Subject: Pagham sites (reference P/134/16/OUT, P/134/16/OUT, P/6/17/OUT and P/25/17/OUT)

I am just emailing to update you on the 4 planning applications in Pagham (reference P/134/16/OUT, P/134/16/OUT, P/6/17/OUT and P/25/17/OUT).

Subject: RE: Pagham South P/140/16/OUT

Figure 13.1 – Chichester Local Plan A27 Whyke Hill junction proposals

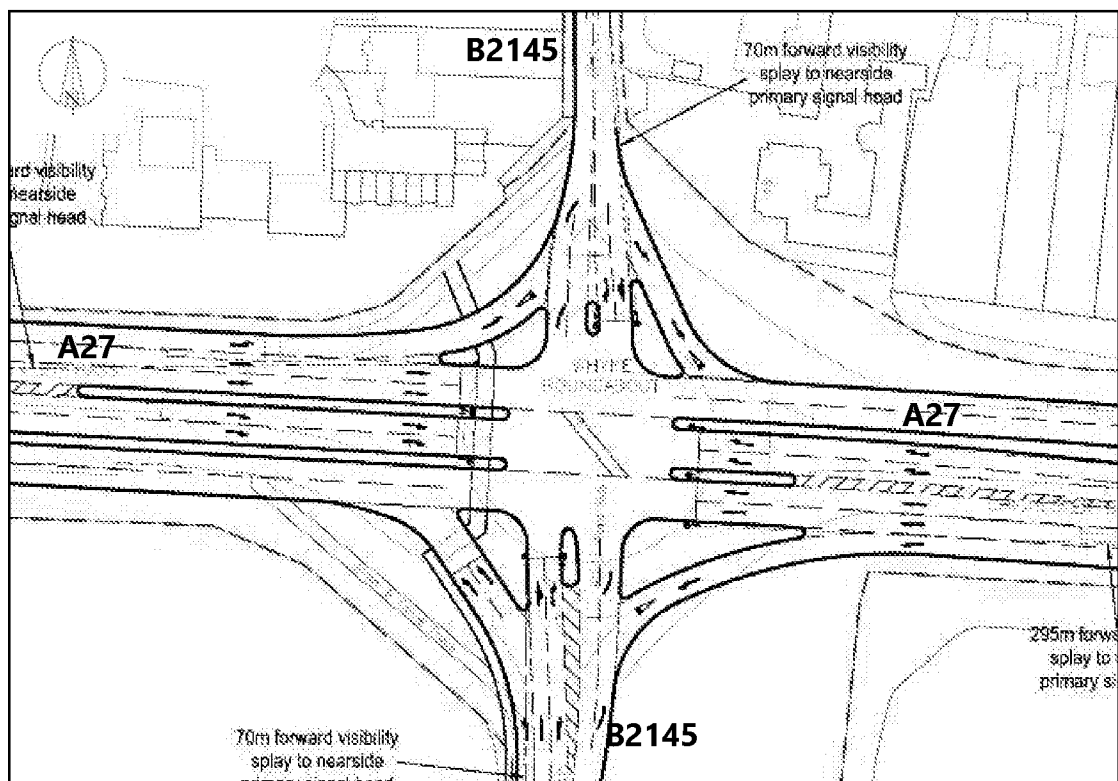
- i. The cost of the original scheme (i.e. that shown on the attached plan ref: JNY8558-12). – This was the information provided by the Spatial Planning Team to the Cost Planning Team. This was the cost information supplied and accepted as part of the Free School permission by 'RPS Group' who are part of the consultant team on these applications.

Figure 13.2 - A27 Whyke Hill junction mitigation scheme

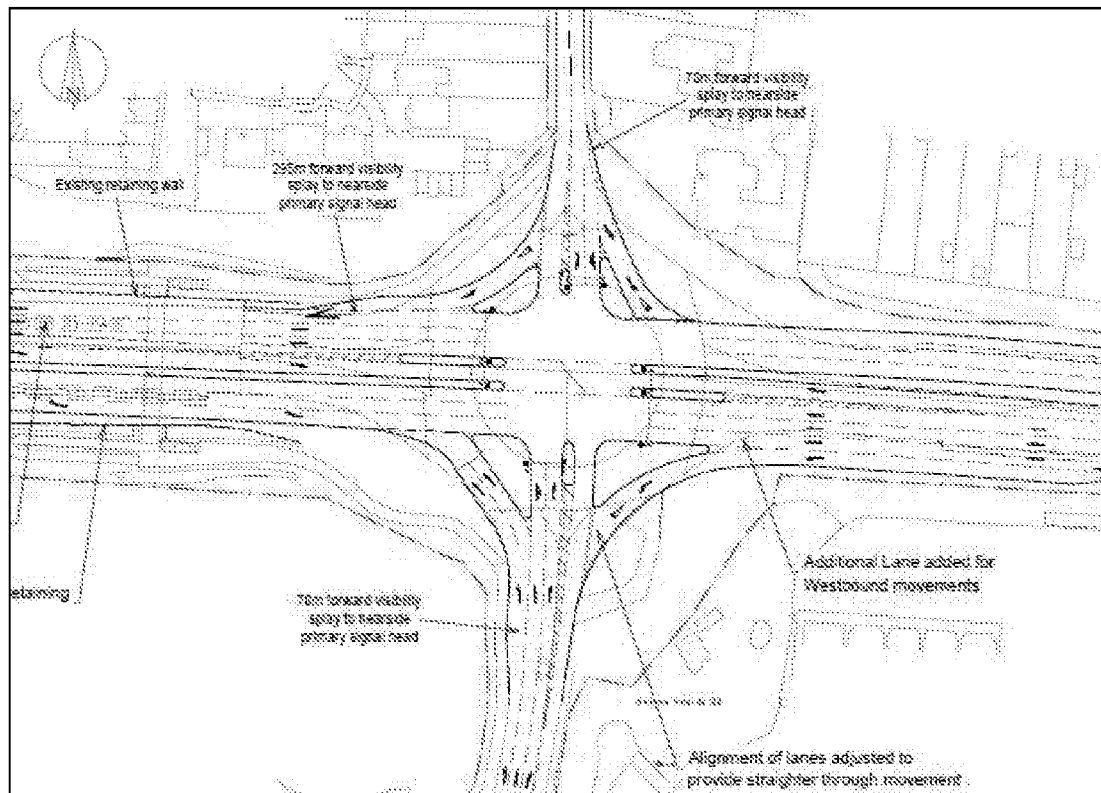
In addition, we note that the costings are based on drawing JNY8840-19/A, but we understand that the plan you finally approved following the RSA was 19/B dated 17/10/17. – As stated above, we, the Highways England Cost Planning Team are neither aware of the new scheme (JNY8840-19B) nor have we seen the drawing so we cannot comment on this. As per my earlier comment above.

We acknowledge that in terms of costings of the whole scheme the differences are probably immaterial, but for the avoidance of doubt going forward it would be beneficial to be working to the approved plan. – The Cost Planning team can only produce the estimates based on the information / drawing provided by the Project teams.

With the above in mind, in accepting a contribution Highways England will need to reduce it's risk and therefore I would be looking at a contribution as previously mentioned of around £881,500 assuming that the RSA amendments have not appreciably increased the amount of construction work necessary.
